DECISION DELEGATED TO HEAD OF PLANNING

Application No: H08-0447-22 **Applicant:** Ms M Firth

Proposal: Proposed Barn Conversion - approved under H08-0428-20. Modification of Condition 2 to allow amendments to previously approved plans.

Location: Hazelwood Grange Hedgefield Hurn Gosberton

Drawing
Planning - Block, Location, garage & Store Plans

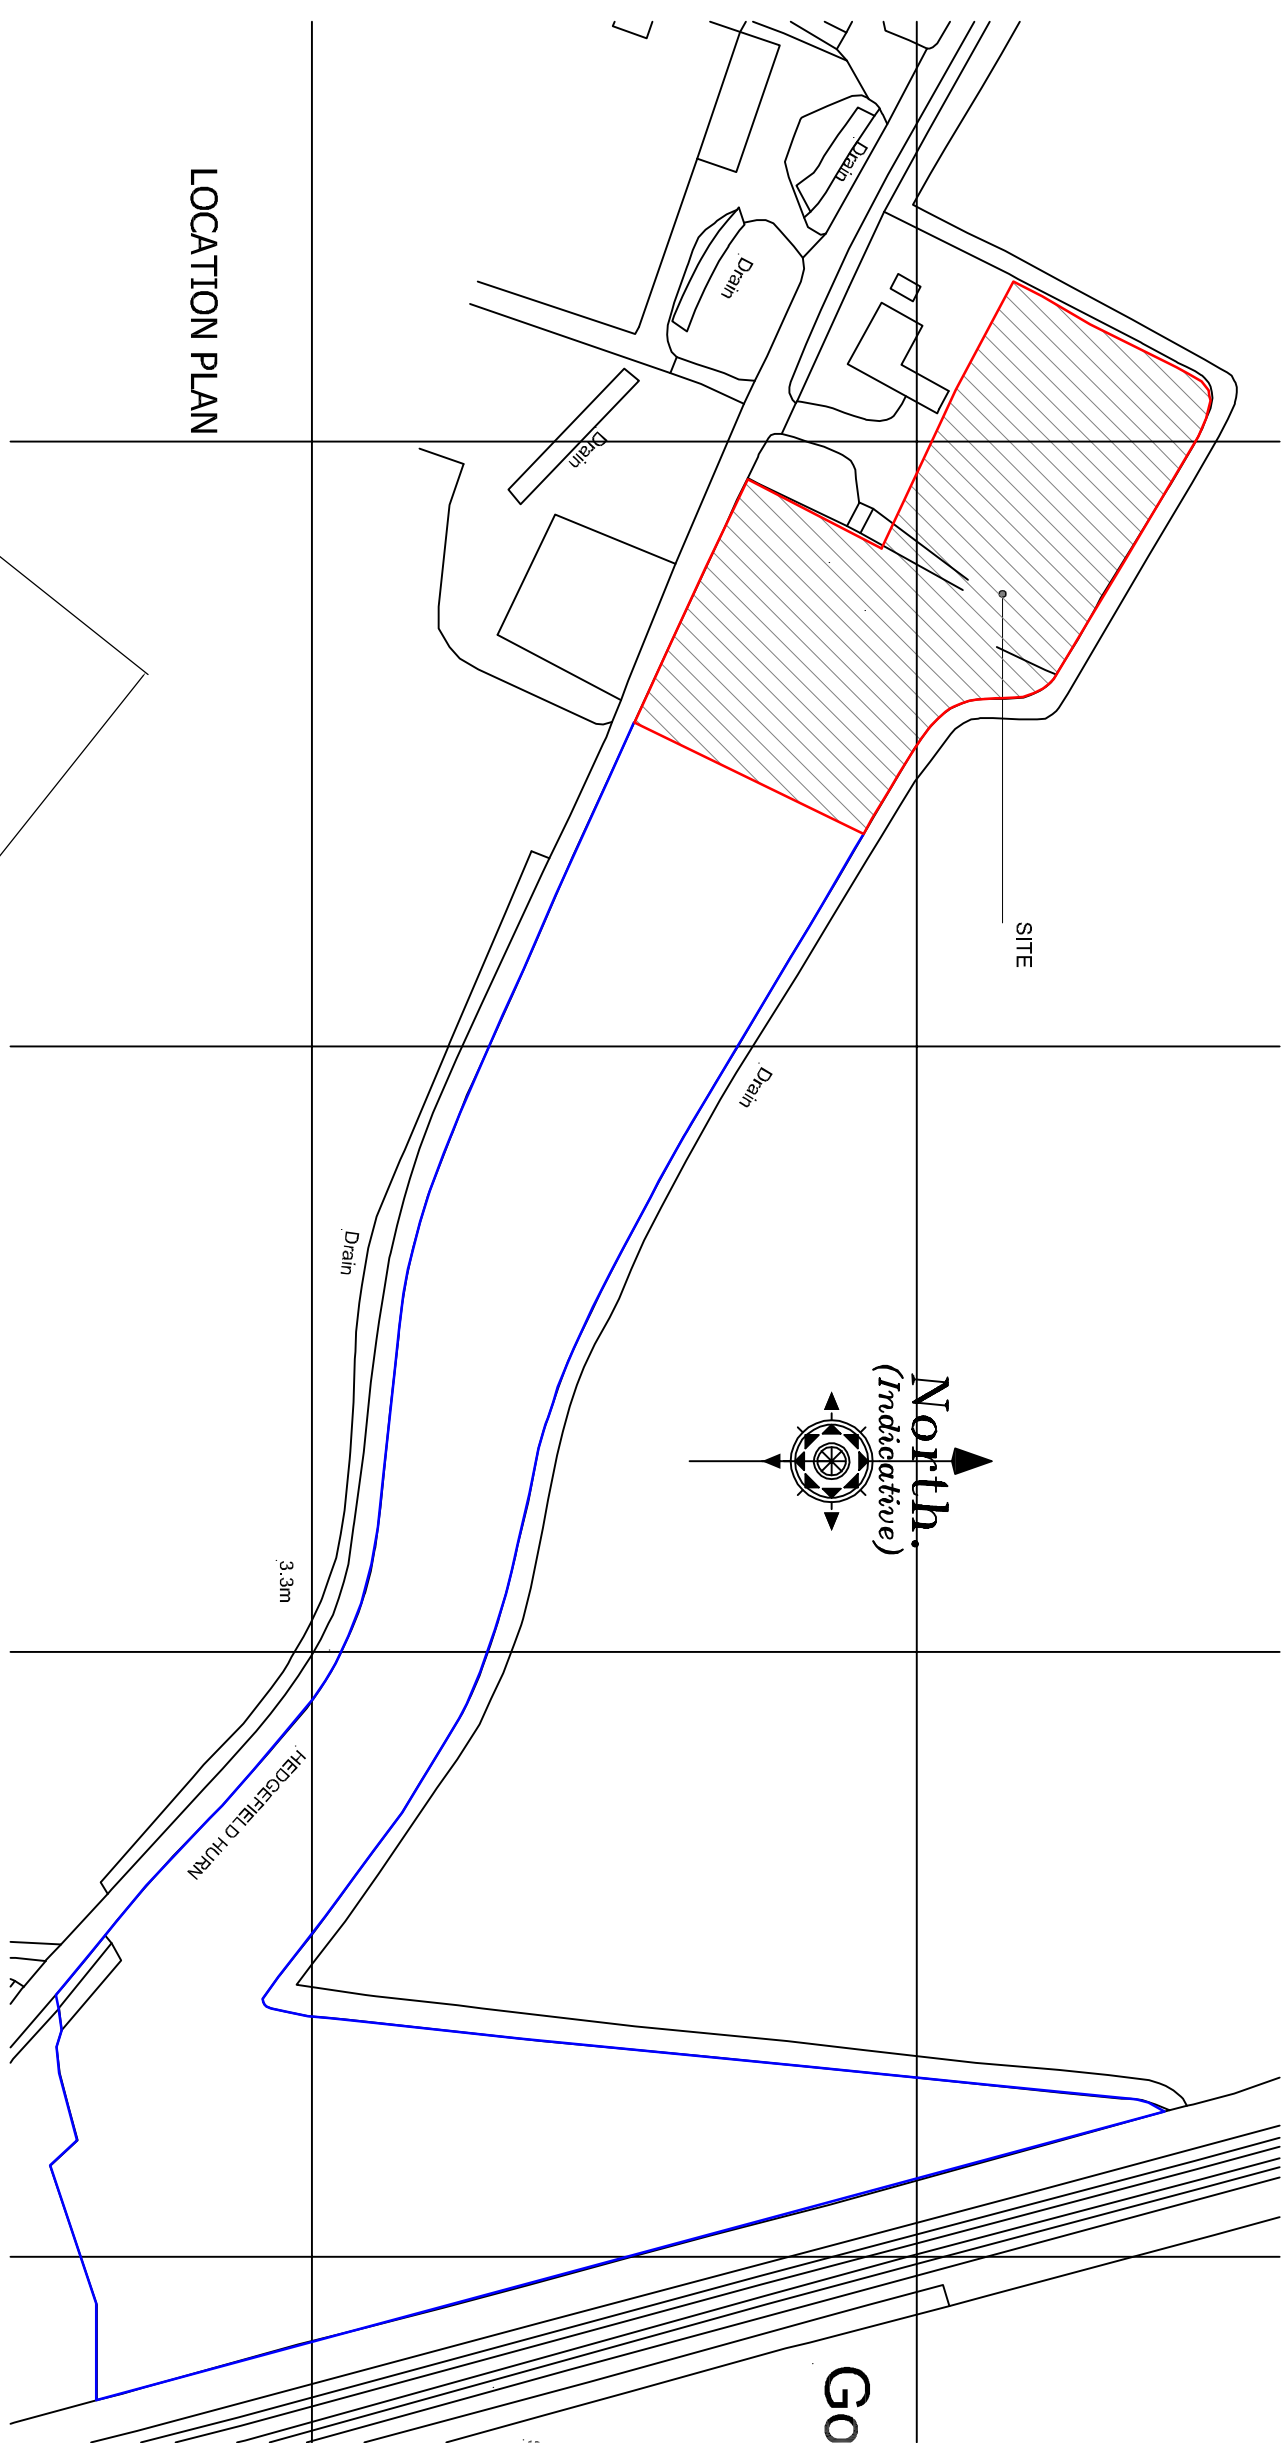
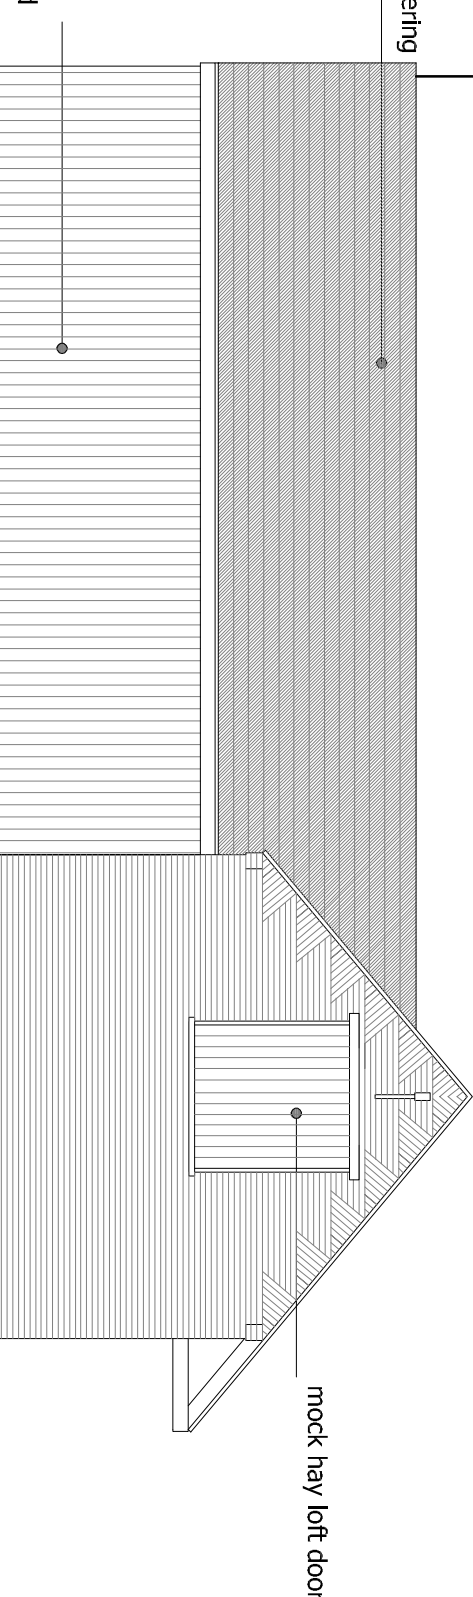
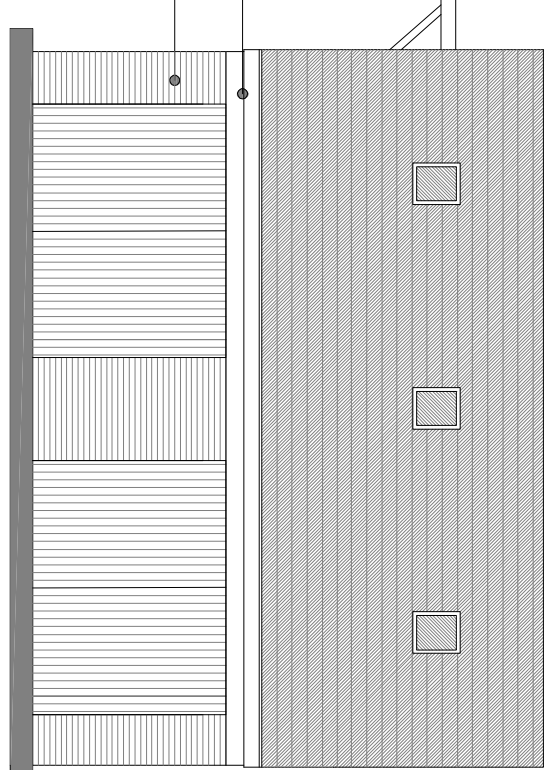
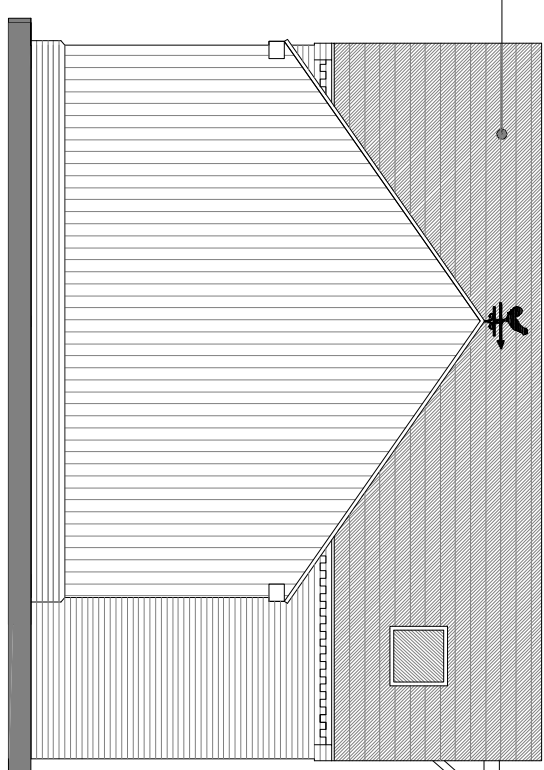
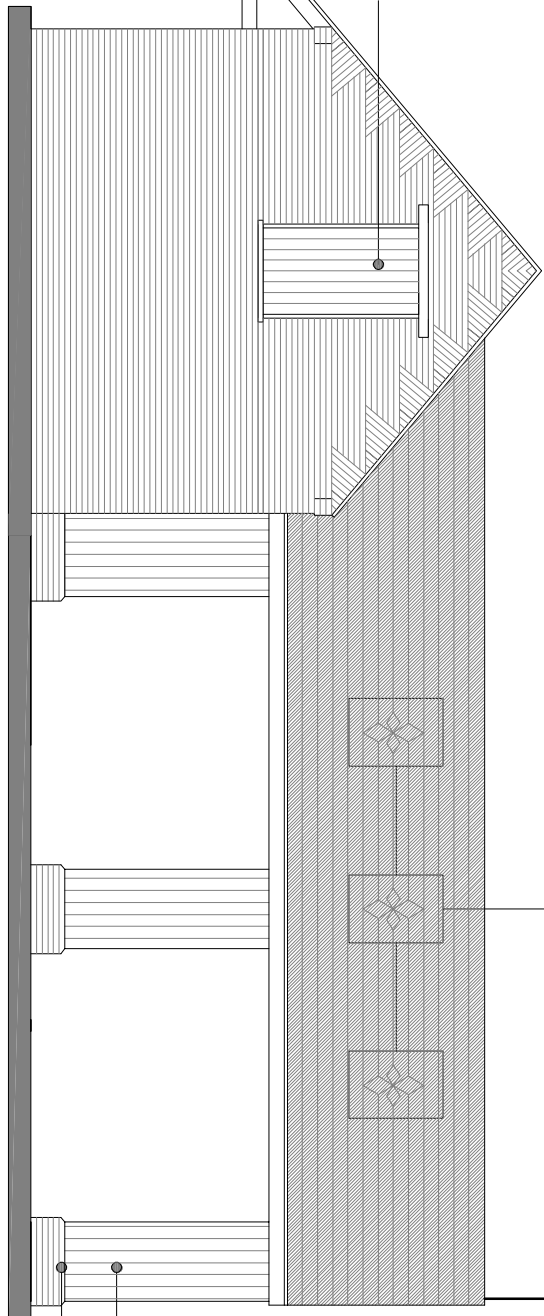
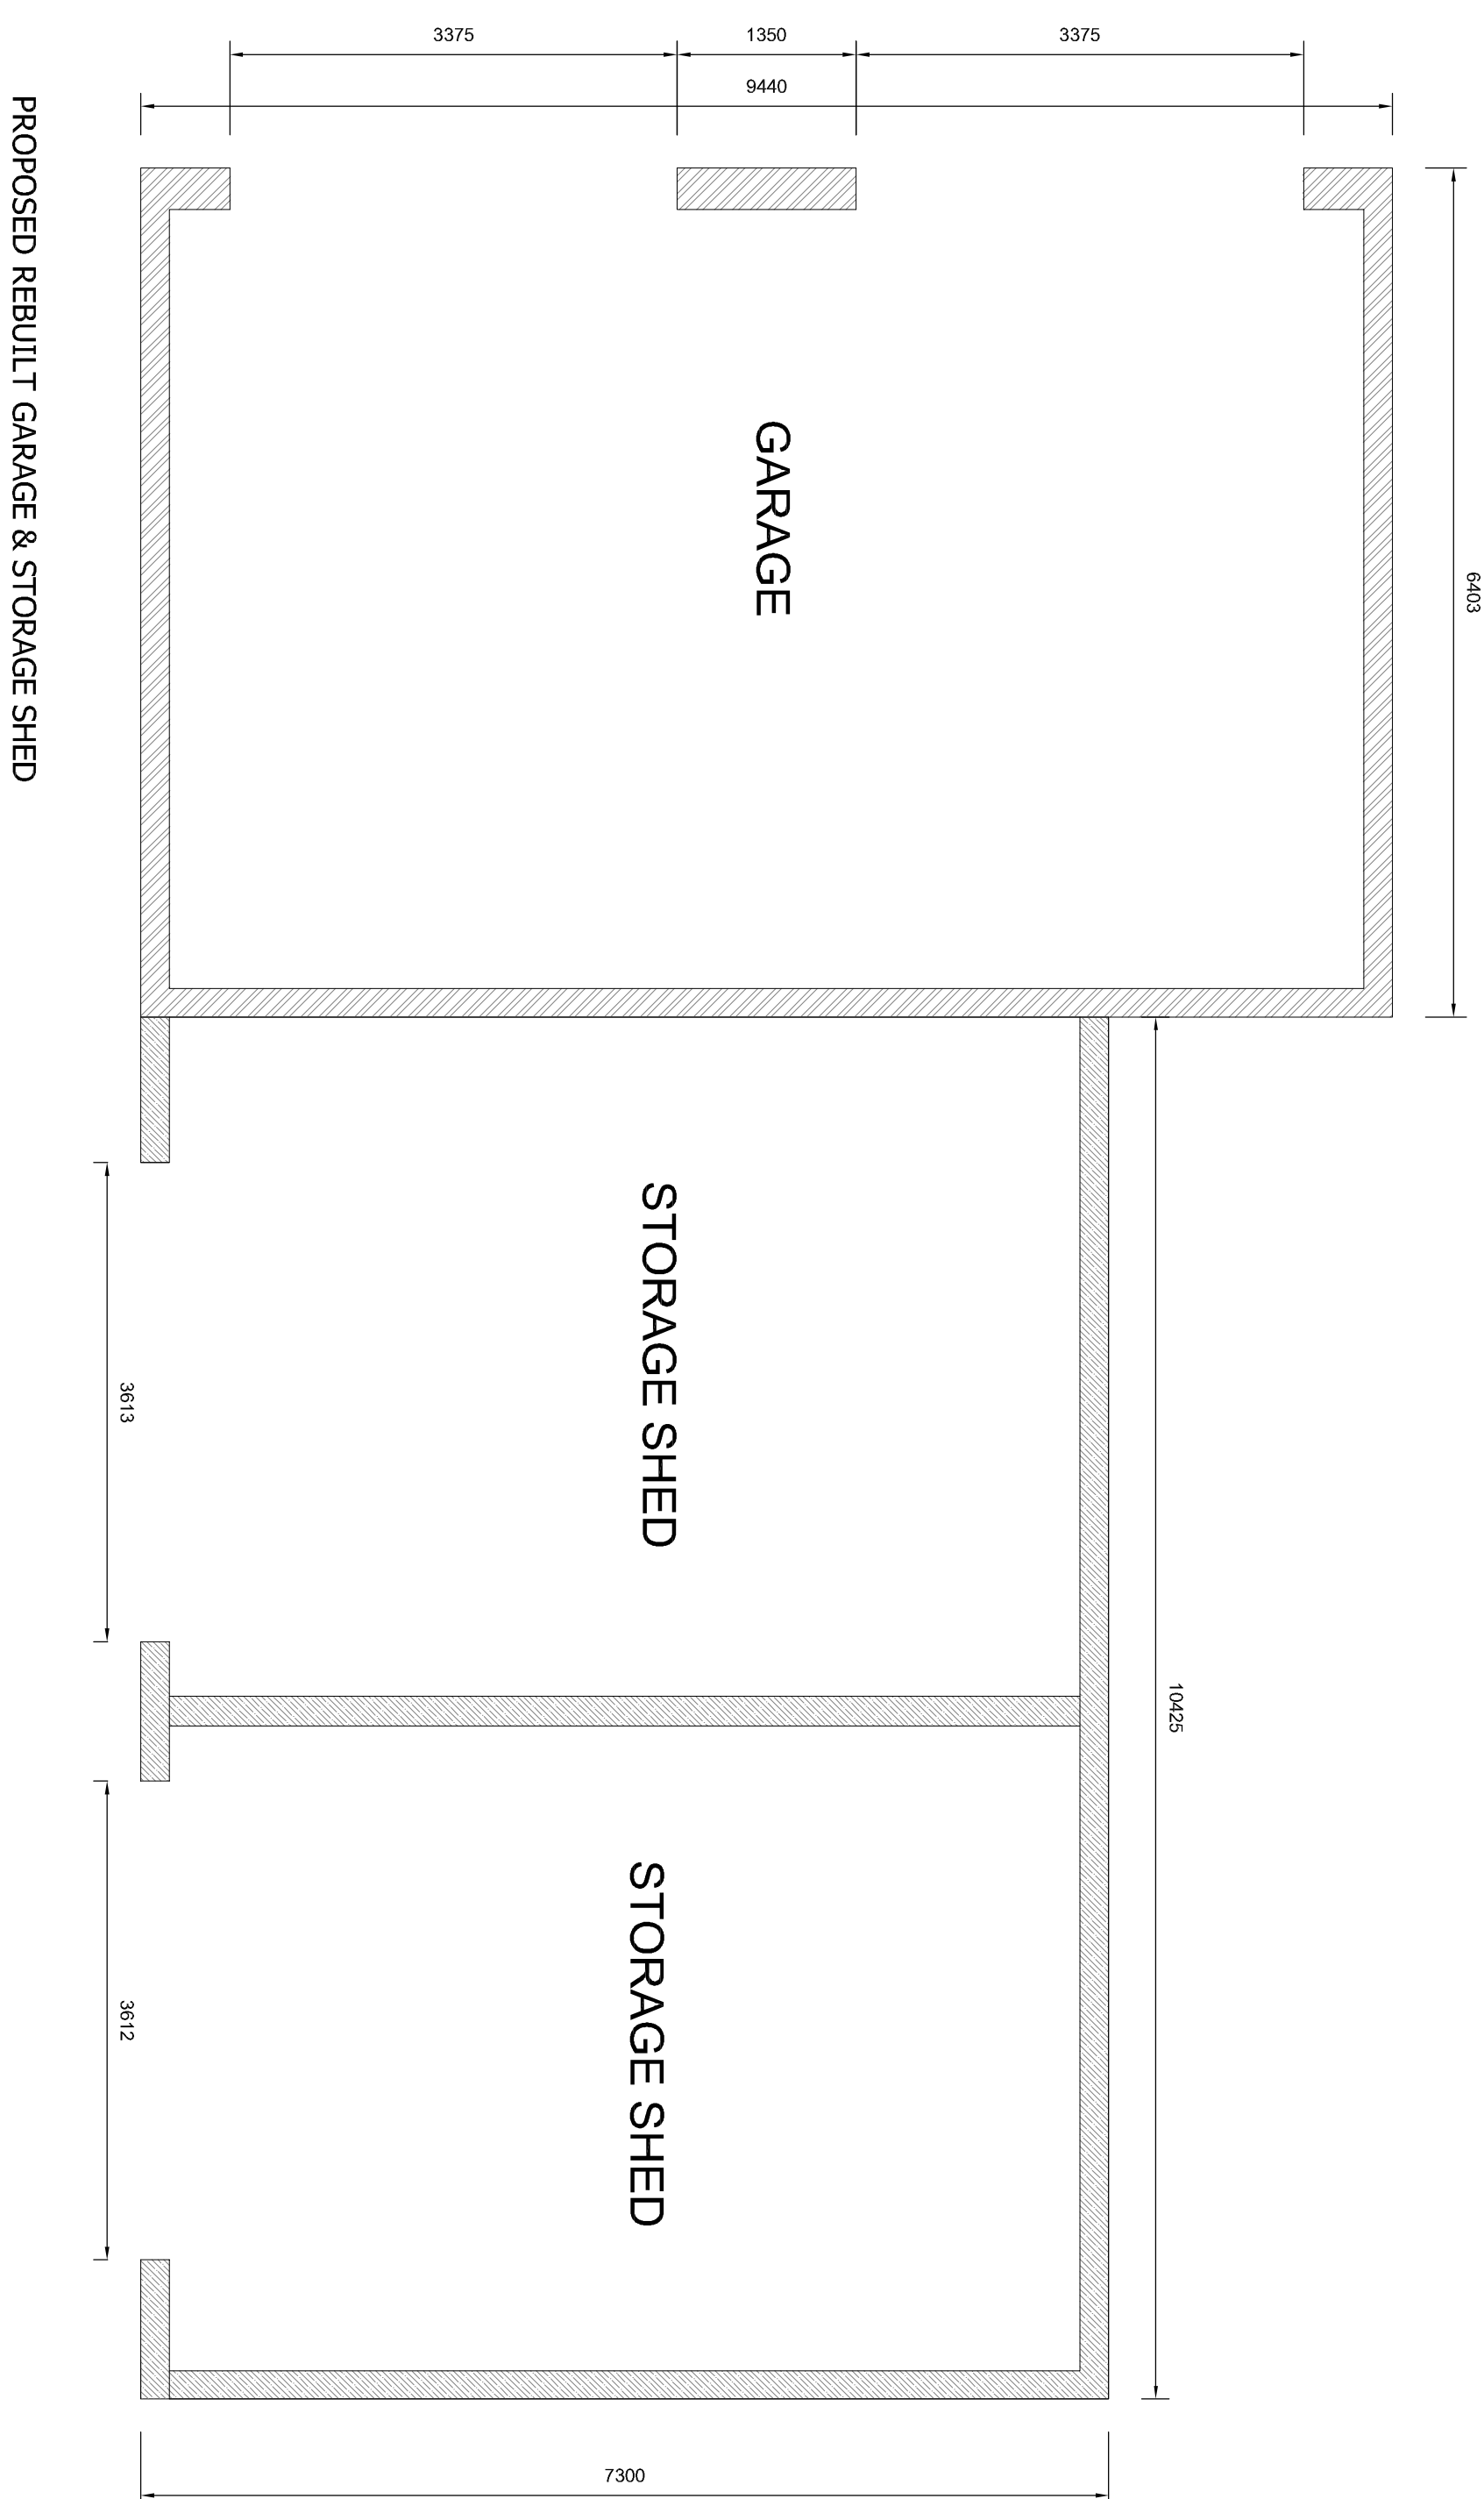
- Alteration of the approved garage plans to change the storage shed section from 3-bay to 2-bay, remove the cupola feature from the roof and change the openings in the garage section from having brick arches to flat arches as well as addition of rooflights to the 1st floor height section of the structure and an additional mock hayloft door on the southern elevation.

- Applicant has not yet filled in rear wall of the storage shed section of the garage block:

- New southern mock hayloft door faces the neighbours and could cause overlooking issues:

- The proposed velux windows were not included within the original approved application:

The applicant reiterates their intention to fill in the rear elevation of the storage block with weatherboarding which suggests they intend to continue with this process. Due to the nature of the material intended to fill in this section of wall, this may be left until a later phase of development.

The proposed mock hayloft doors are not functional features and will serve purely aesthetic purposes. They do not create any additional overlooking risk.

This application seeks consent for these windows, which face back to the host property, causing no risk of overlooking to any neighbouring property.

Furthermore, the proposed south facing hay-loft door in the gable of the garage block is only a mock-door used for its aesthetic contributions, it will not be opening and there is not a floorspace from which it can be accessed. It presents no risk of overlooking to the south.
